Subject: Arundel Road, Angmering A/46/22/RES and A/282/22/RES

Please see the following comments:

Indicative SuDS Basin Landscape Sections

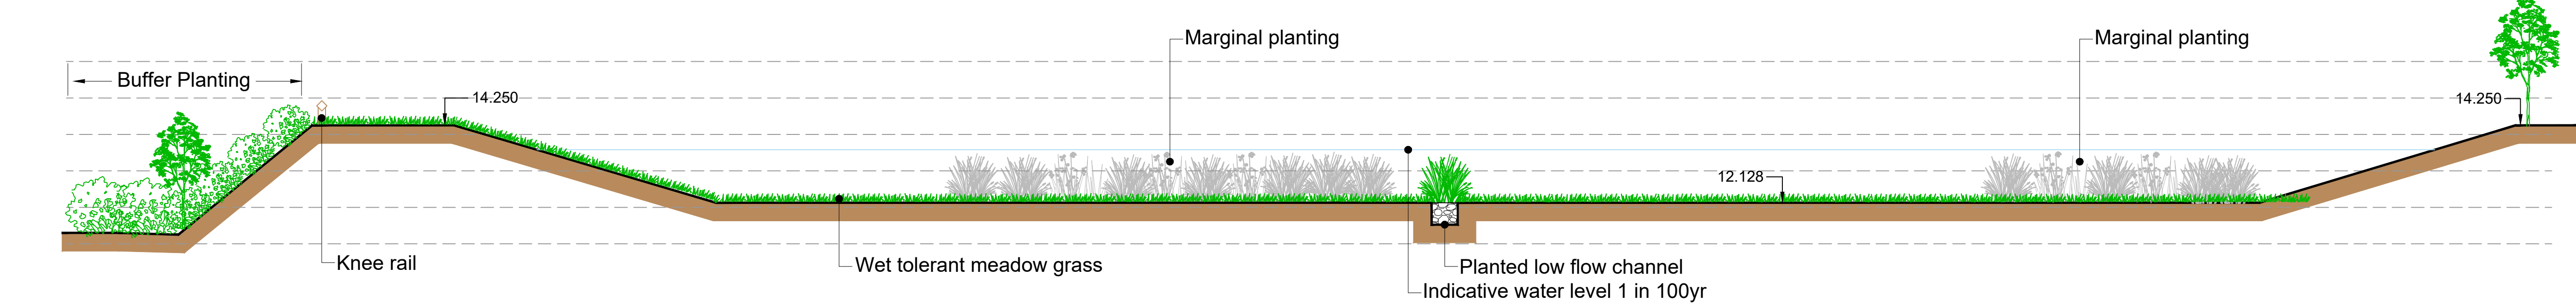
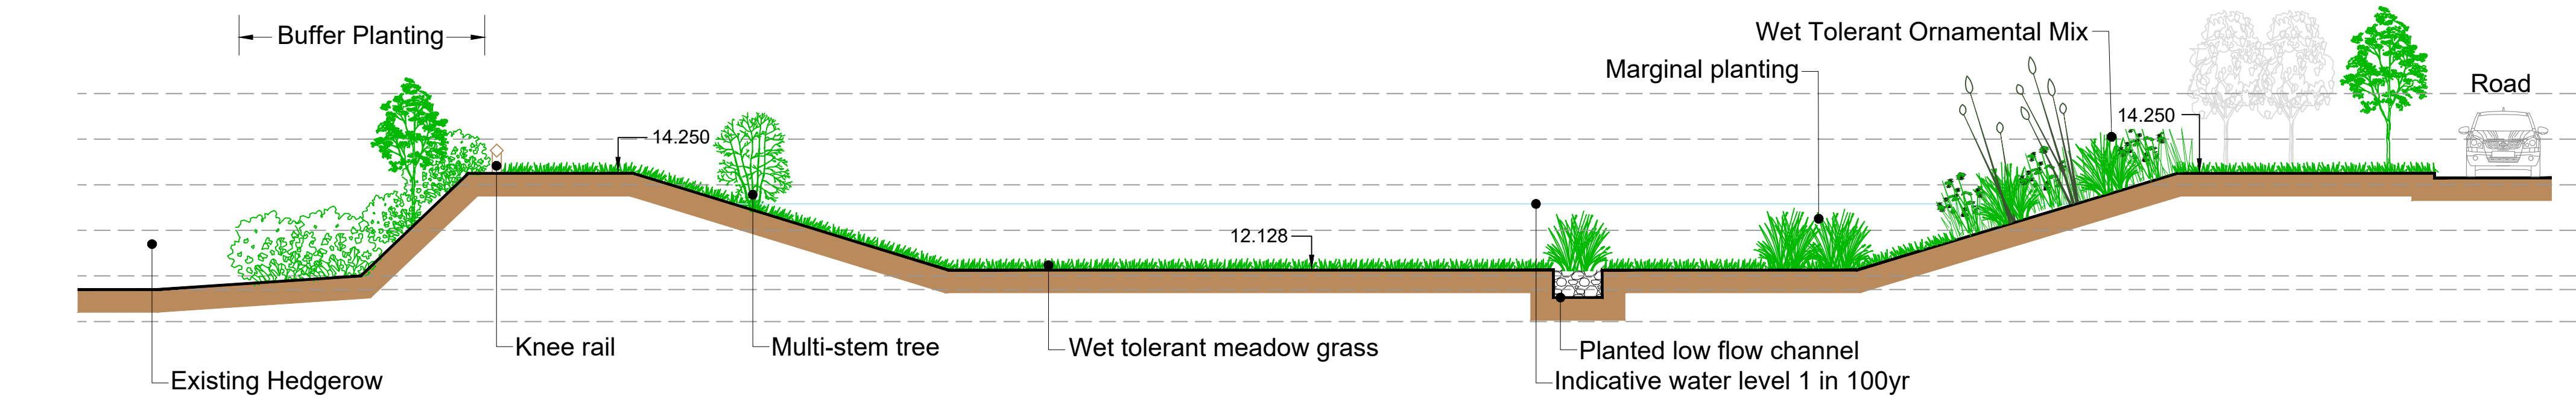
- Unlike with A/46/22/RES there do not appear to be any cross sections of the attenuation pond.
- There is no detail of the play provision or how the link path to the public RoW adjacent to the western boundary will be achieved (as it crosses a ditch). We can however use conditions to enable this to be agreed at a later date.
